3 November 2020

## RE: HARBOURSIDE SHOPPING CENTRE REDEVELOPMENT | SSD-7874

City Plan Strategy & Development P/L (City Plan) has been engaged by Colliers International, acting on behalf of the ground lessee of the Novotel and Ibis Hotels. This submission is in addition to the previous submission prepared by City Plan, dated 29 April 2020, and responds to the amended proposal submitted by the proponent in relation to the Harbourside Shopping Centre site.

Image 82 Envelope Plan

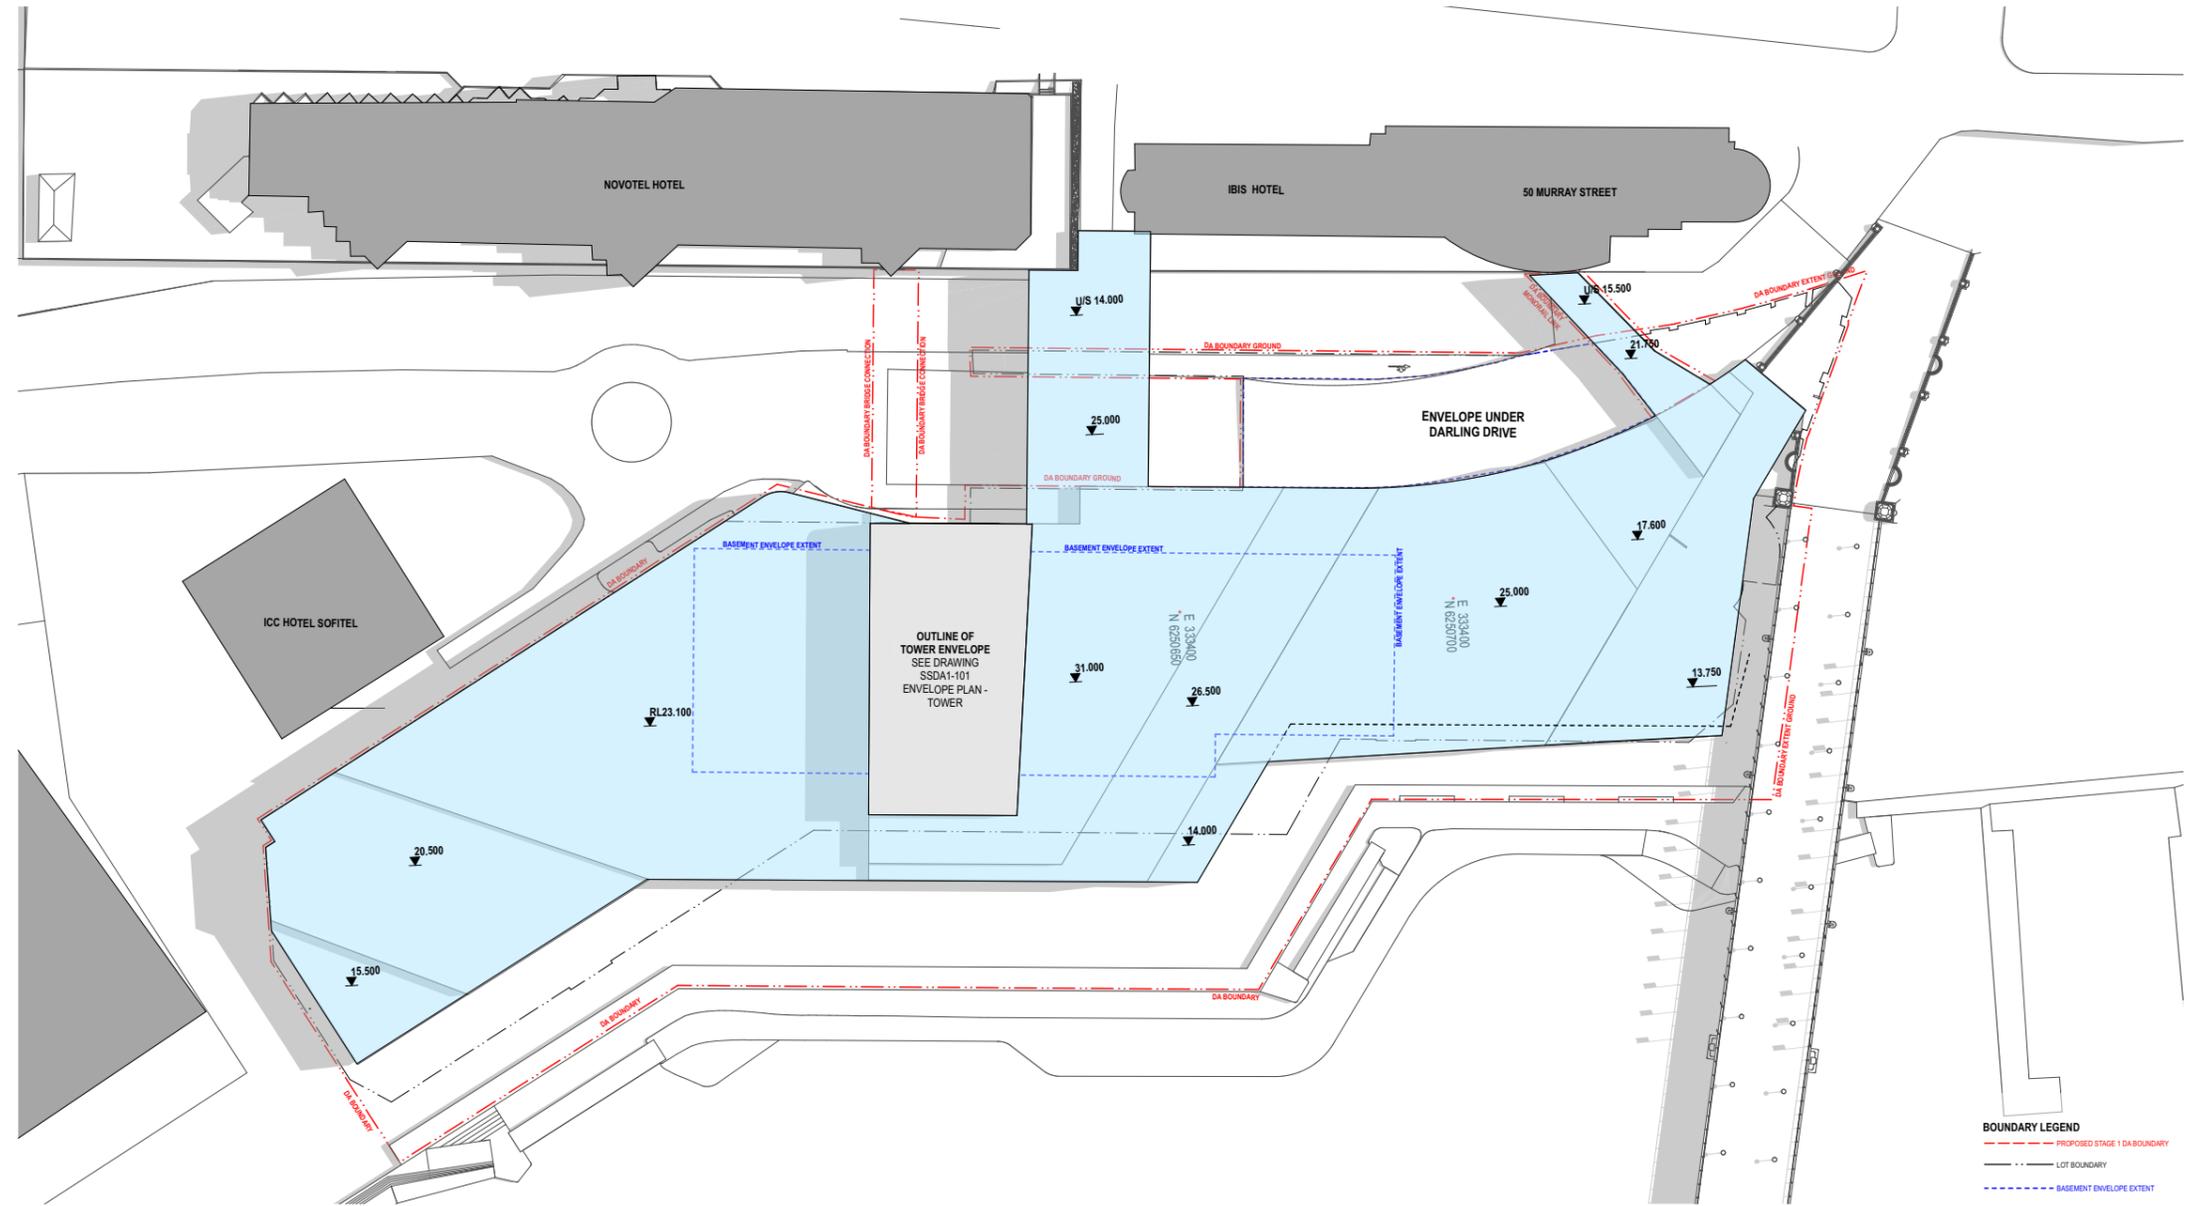
It is acknowledged that the proposal has been amended following public exhibition. In particular, it is noted that a small portion of the proposed podium's northern section has been reduced by approximately 1 - 2 storeys. Despite this amendment, view impacts from communal restaurants in both the Novotel and Ibis Hotel's towards the city skyline will remain severely impacted. In some cases, Darling Harbour water views will also be impacted. This is demonstrated by the proponent's photomontage analysis submitted as part of the revised scheme, extracts of which are in Tables 1 and 2 below. It should be noted that in some cases, the impacts are, in fact, greater than demonstrated below as several photomontages are depicted from at least 1 level above the restaurant floor levels (i.e. the restaurants are located on the ground floor whilst most photomontages are from levels 1 or higher).

Given the above, it is not unreasonable for all or most of such views to be retained given their importance generally and their importance to the operation of the hotels. As such, further modelling should take place to confirm a proposed envelope which identifies this outcome. Our analysis suggests that the proposed podium should be no greater in height than the existing Harbourside Shopping Centre roof line.
